Our ref: DOC20-67284
Senders ref: SSD-10288

Subject: Culcairn Solar Farm (SSD 10288) - Review of Environmental Impact Statement

ATTACHMENT A – BCD assessment summary for Culcairn Solar Farm Environmental Impact Statement (SSD 10288)

Figure 9-1 Location of serious and irreversible impacts

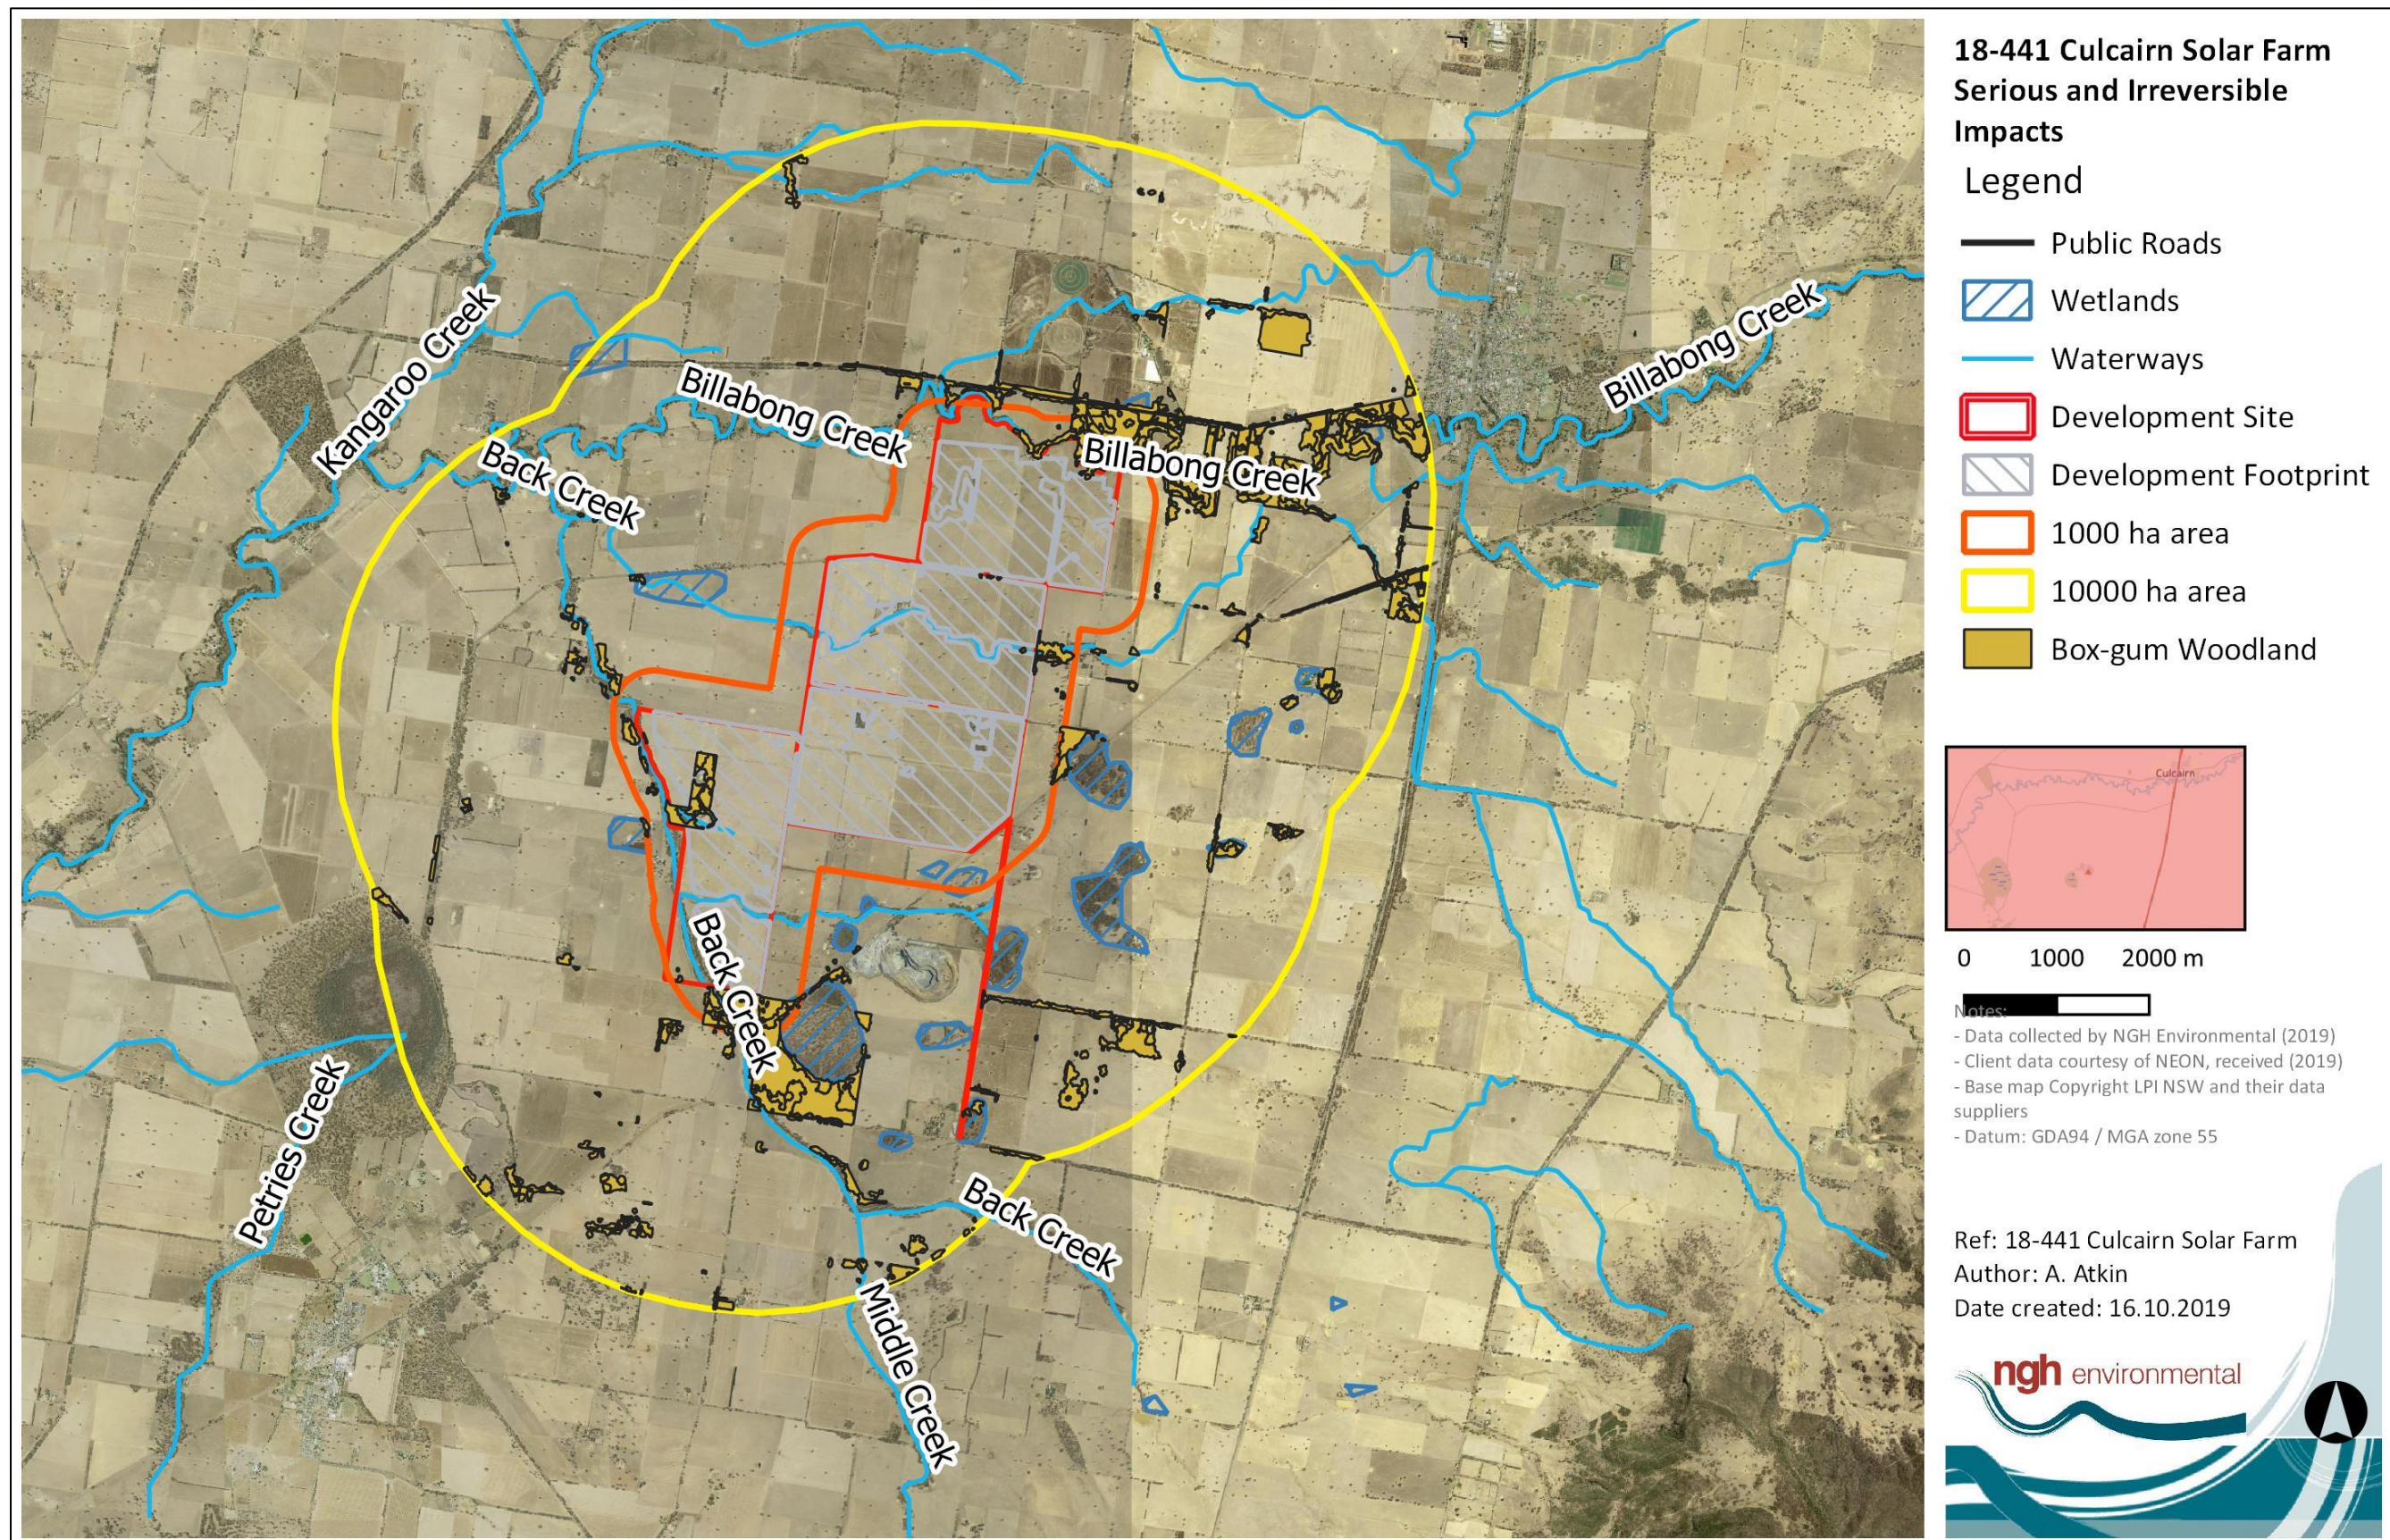
8. The potential for serious and irreversible impacts (SAIL) on the Box-Gum Woodland Threatened Ecological Community (TEC) (PCT 277) is not clear.

Section 10.2.2.1(b) of the BAM requires that information relating to both direct and indirect impacts on the SAIL are provided to the decision maker. In this way, the Table at 9.2.1(b) should include areas that are directly impacted by clearing including the 79 scattered paddock trees associated with the SAIL candidate TEC. That loss may have direct or indirect impacts on the TEC.

We highlight the loss of 71 hollow bearing paddock trees including 58 typically associated with the SAIL candidate TEC in the Lower Slopes IBRA subregion. The judgement of the decision maker regarding the risk of serious and irreversible impact must be informed by the direct and indirect impact of the net loss of the SAIL candidate TEC across the development site, including scattered paddock trees associated with the TEC, especially where they provide hollows.

Regarding the Culcairn Solar Farm, the applicant has not evaluated the extinction risk to the TEC entity (PCT 277) according to the three principles outlined in section 3.2.2 of the *Guidance to assist a Decision Maker to Determine a Serious and Irreversible Impact* (DPIE 2019).

The likelihood of SAI on Box-Gum Woodland Threatened Ecological Community (PCT 277) should be assessed in further detail, including a more holistic assessment of indirect and prescribed impacts across the development site including 79 scattered paddock trees associated with the TEC and especially the 58 trees with hollows.
